Aldwick Bay Company Ltd

81a The Fairway, Aldwick Bay Estate.

AW/31/17/HH

"Single storey rear extension, new porch to side elevation, fence to north elevation & enlargement of lean-to outbuilding"

PROPOSED ELEVATIONS

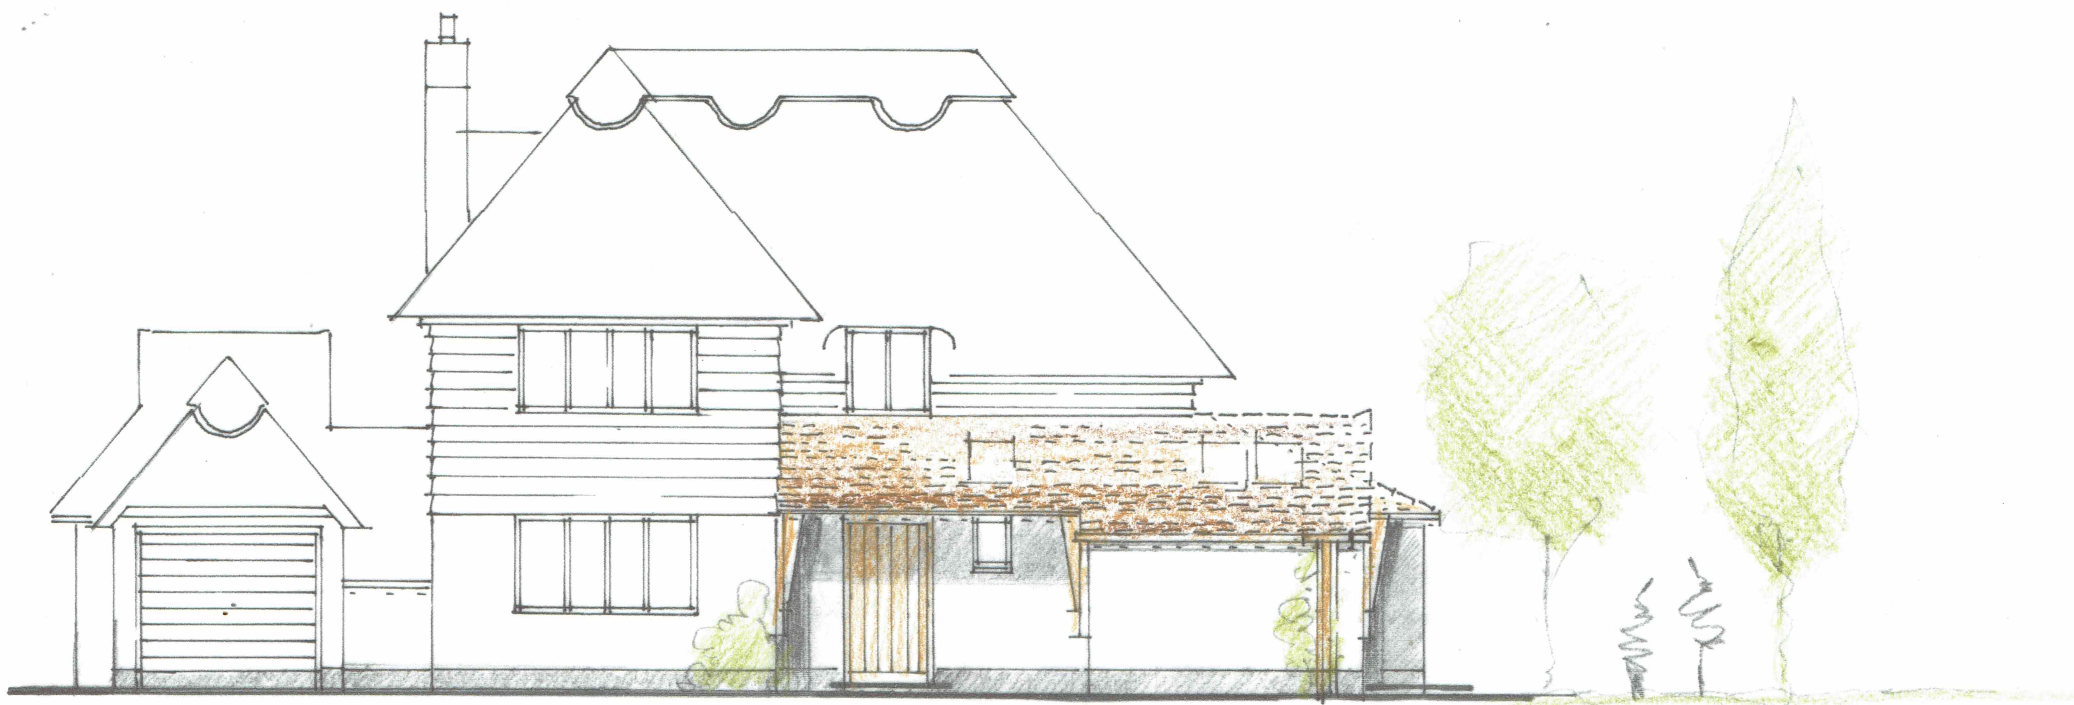
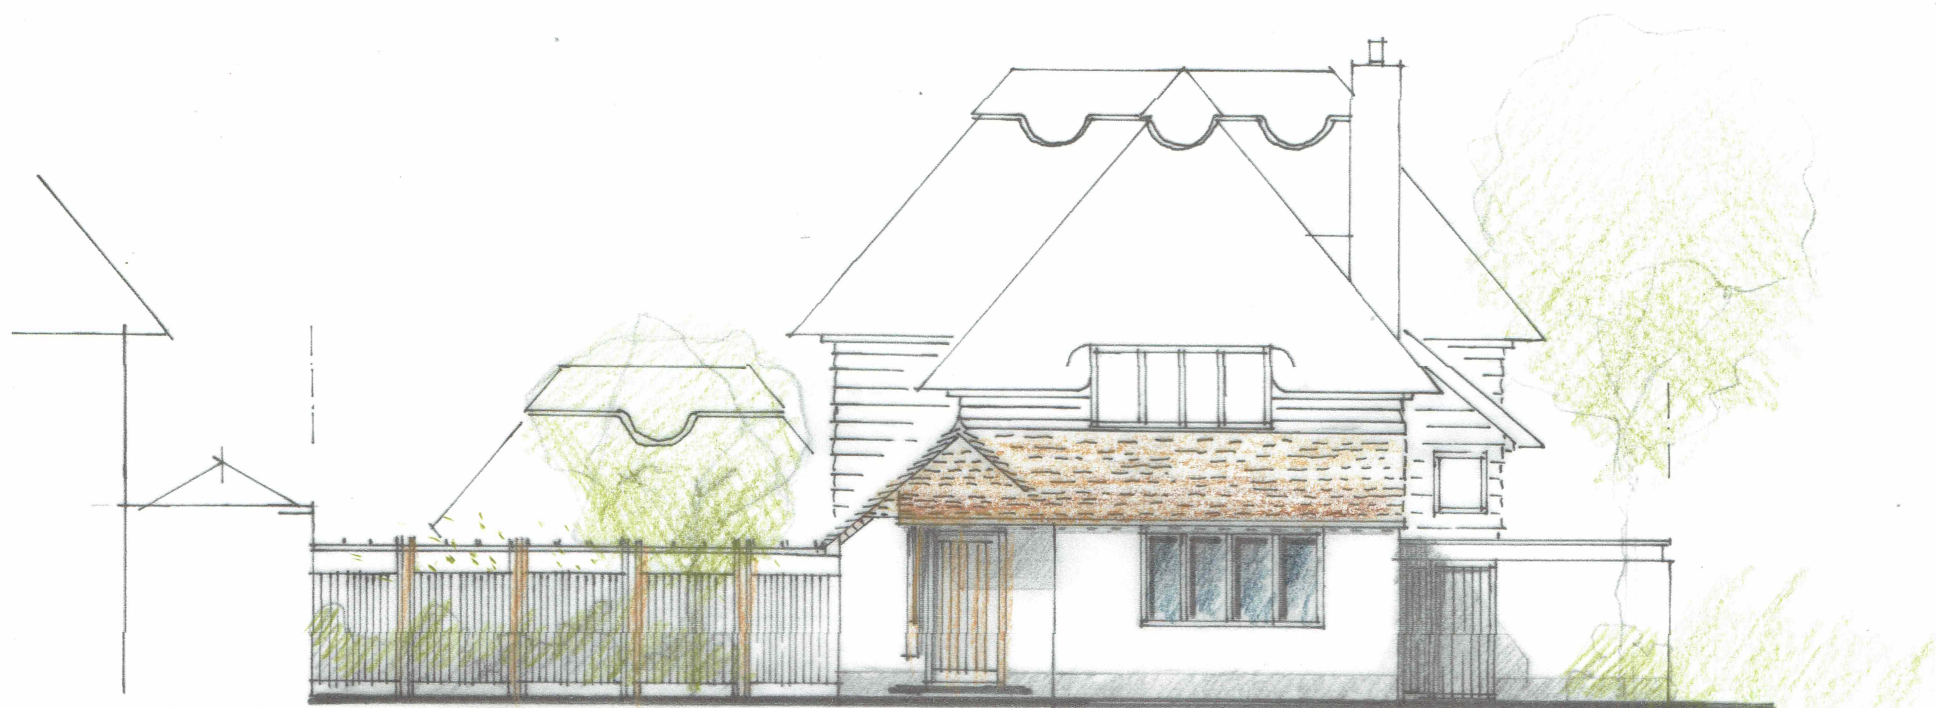
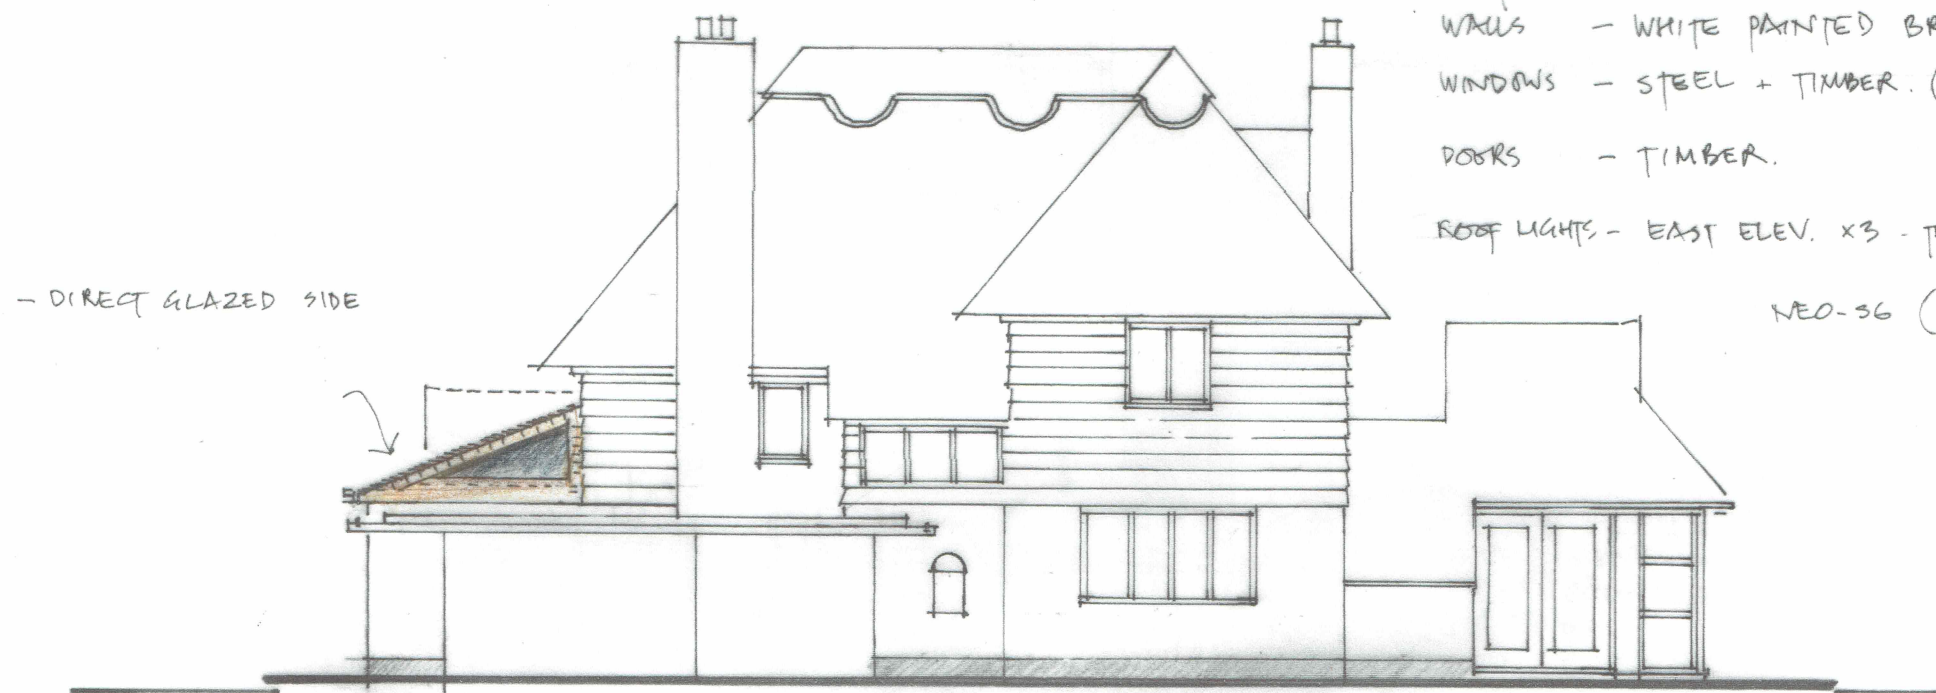
Materials as noted in the application to match in colour and texture the existing wall, windows and doors. Roof materials and detailing to match those on the previous front extension.
